Transport
for NSW

Notification of a Section 96 (1A) Modification Application to Modify the South West Plot (SW Plot) Component of the Sydney International Convention, Exhibition and Entertainment Precinct (SICEEP), Darling Square Project (SSD 6011 MOD1)

Thank you for your dated 6 May 2015 requesting Transport for NSW (TfNSW) comment on the modification to the above development application.

DESIGN DEVELOPMENT
SOUTH WEST PLOT
SW3 TYPICAL TOWER PLAN
LEVELS 06-36

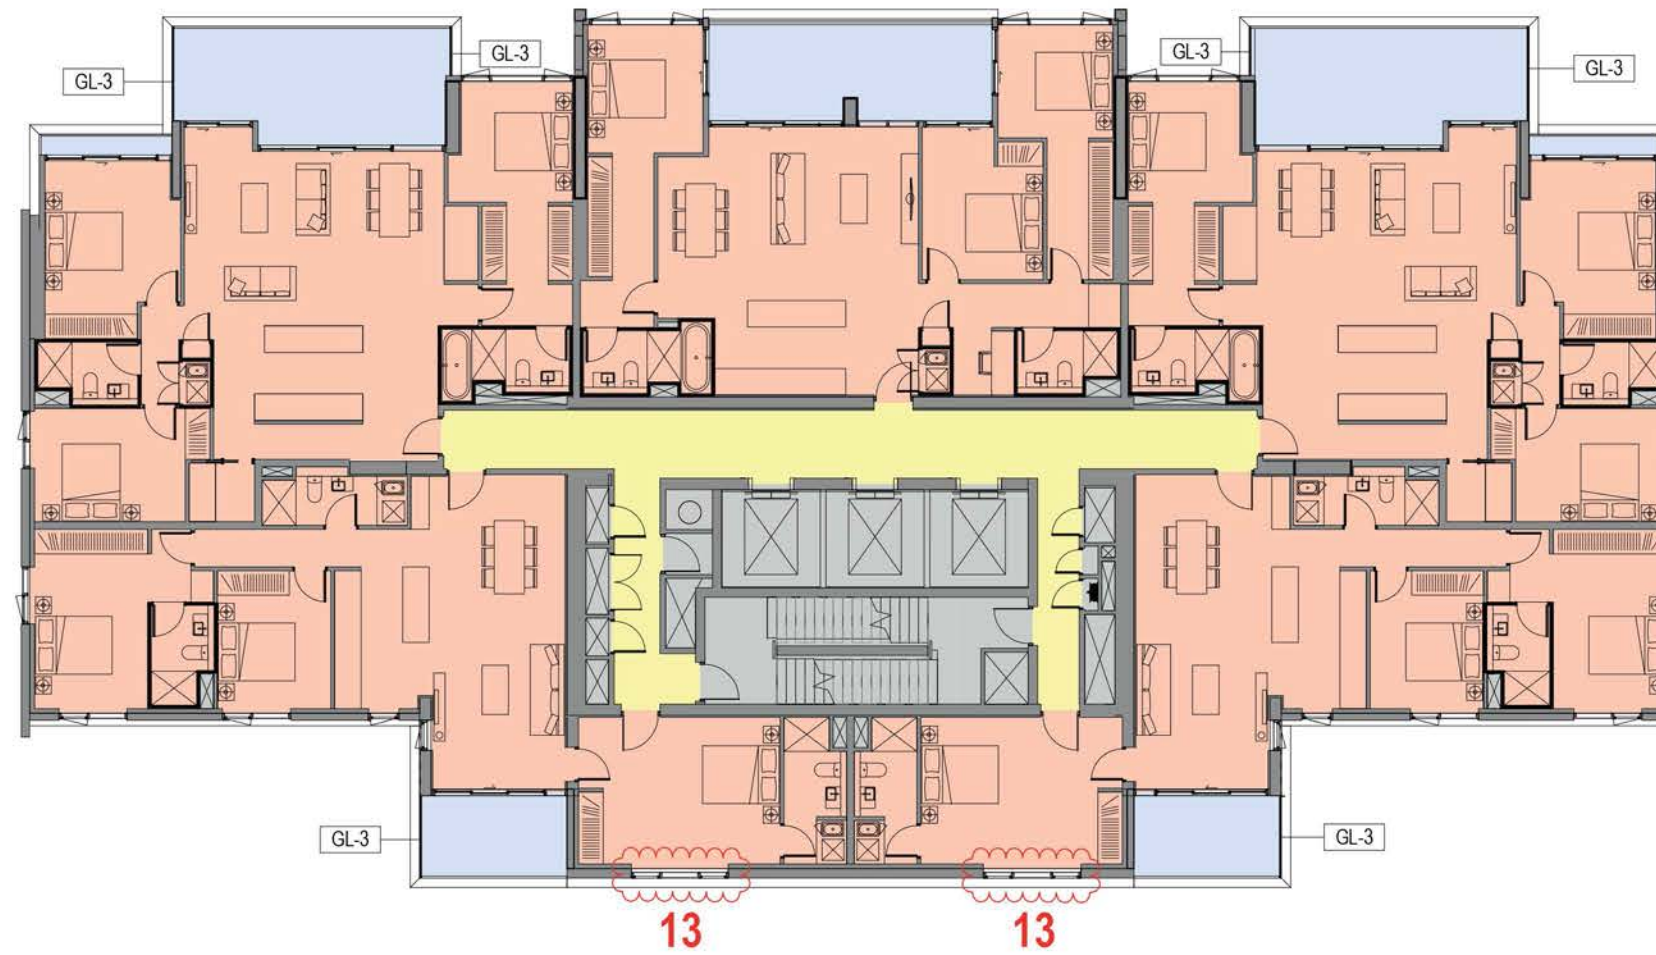
- Based on Supplementary Design Report, Paragraph 6.11 of the ASA External Development Standard provides that windows and balconies must mitigate the risk of anything being thrown onto the railway infrastructure. Plan SK 225 shows that the balconies on the building on South West Plot facing south will have full height privacy screens. TfNSW requests that the proponent design and construct these items to meet the ASA Standard.
